EP-22-0026_1 Eagle Rising Filing No. 1 Final Plat
Location: E½ Section 29, T12S, R65W, 6th P.M.
38.9785, -104.6898
El Paso County File No. SF2225

With this referral, CGS received a request to provide Review Comments (Email August 2, 2022); Final Plat (MS Civil Consultants, Inc., June 30, 2022); and Soil, Geology, and Geologic Hazard Study (Entech Engineering, Inc., June 29, 2022).

EAGLE RISING FILING NO. 1
FINAL PLAT
JOB NO. 43-043
DATE PREPARED: 06/30/2022
DATE REVISED: 08/28/2023

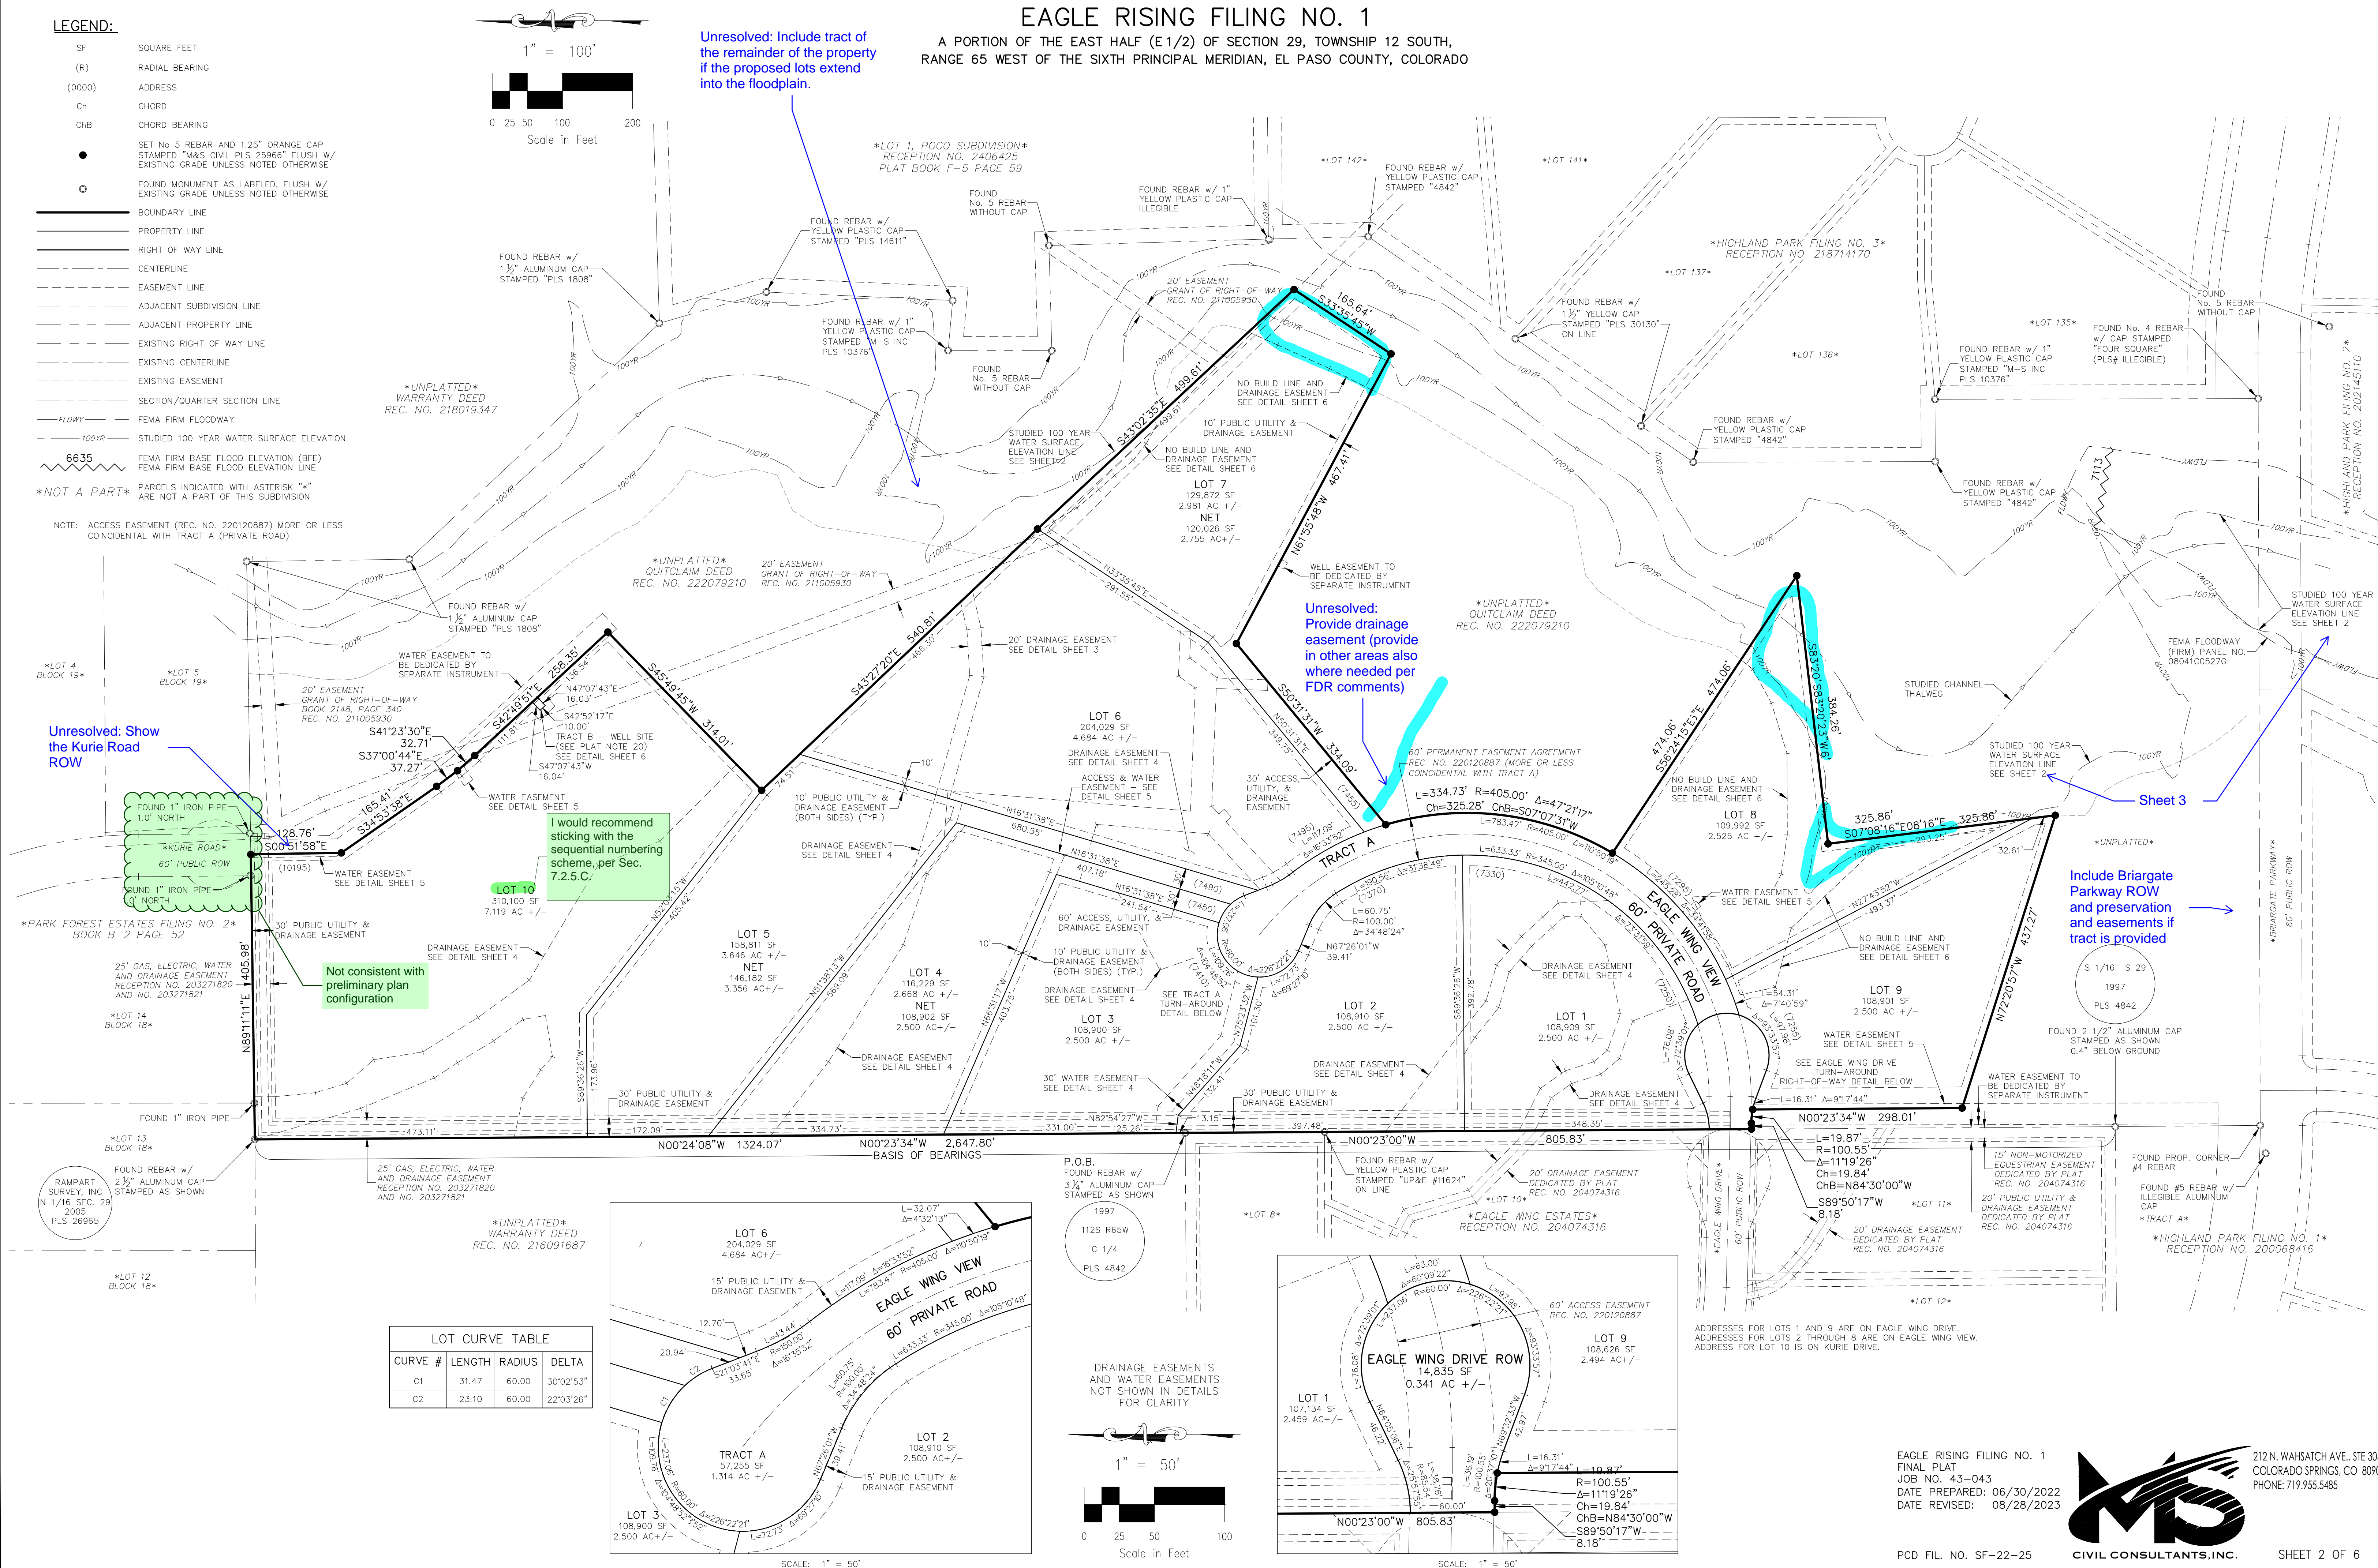
CGS recommends a plat note be added that no basements or inhabitable below-grade areas are allowed unless groundwater monitoring (through the annual seasonal fluctuations) before construction demonstrates that below-grade areas can maintain a minimum of 3 feet between the bottom of the foundation and the groundwater, or site grading indicates that it will mitigate the depth to groundwater.

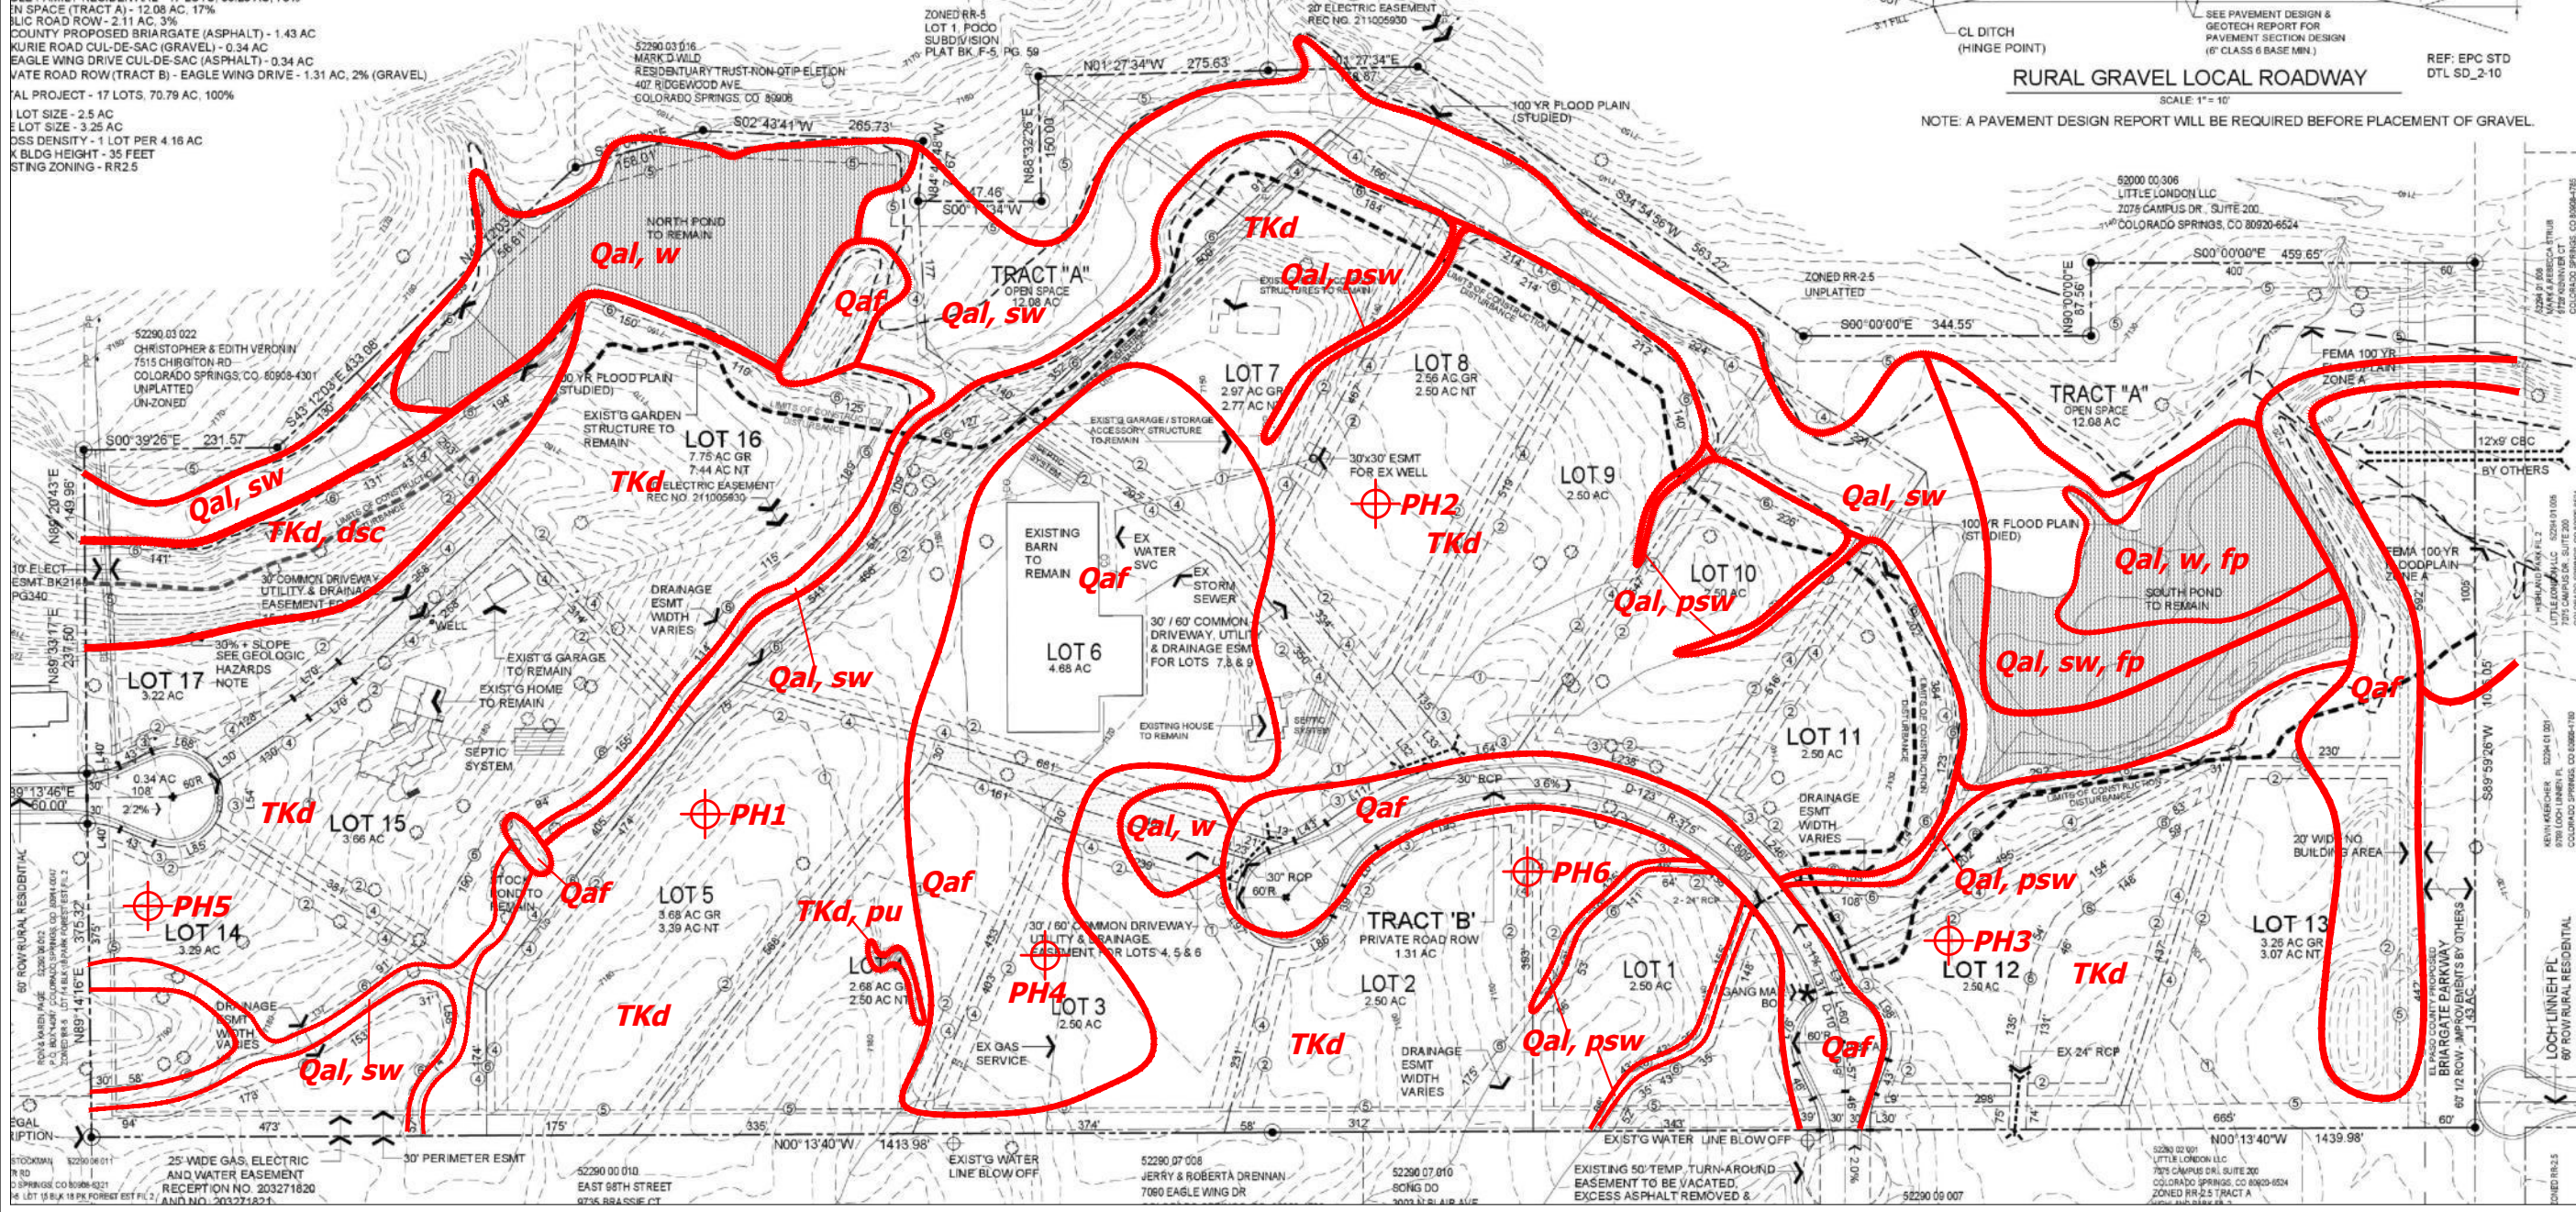
Potentially Unstable Slopes and Downslope Creep. As indicated in Entech’s report (page 10), in reference to potentially unstable slopes, “some of the very steep slopes along the north pond area and a cut-slope in the central area on Lot 4 have been identified as potentially unstable.” CGS agrees with Entech’s recommendation, “Structures should be located a minimum of 20 feet (sic) from any potentially unstable slope unless stabilized,” and “Due to the size of the lots, it is anticipated these areas can be avoided by construction.” Careful consideration of the placement of structures and improvements is recommended to avoid potentially unstable slopes and downslope creep areas.
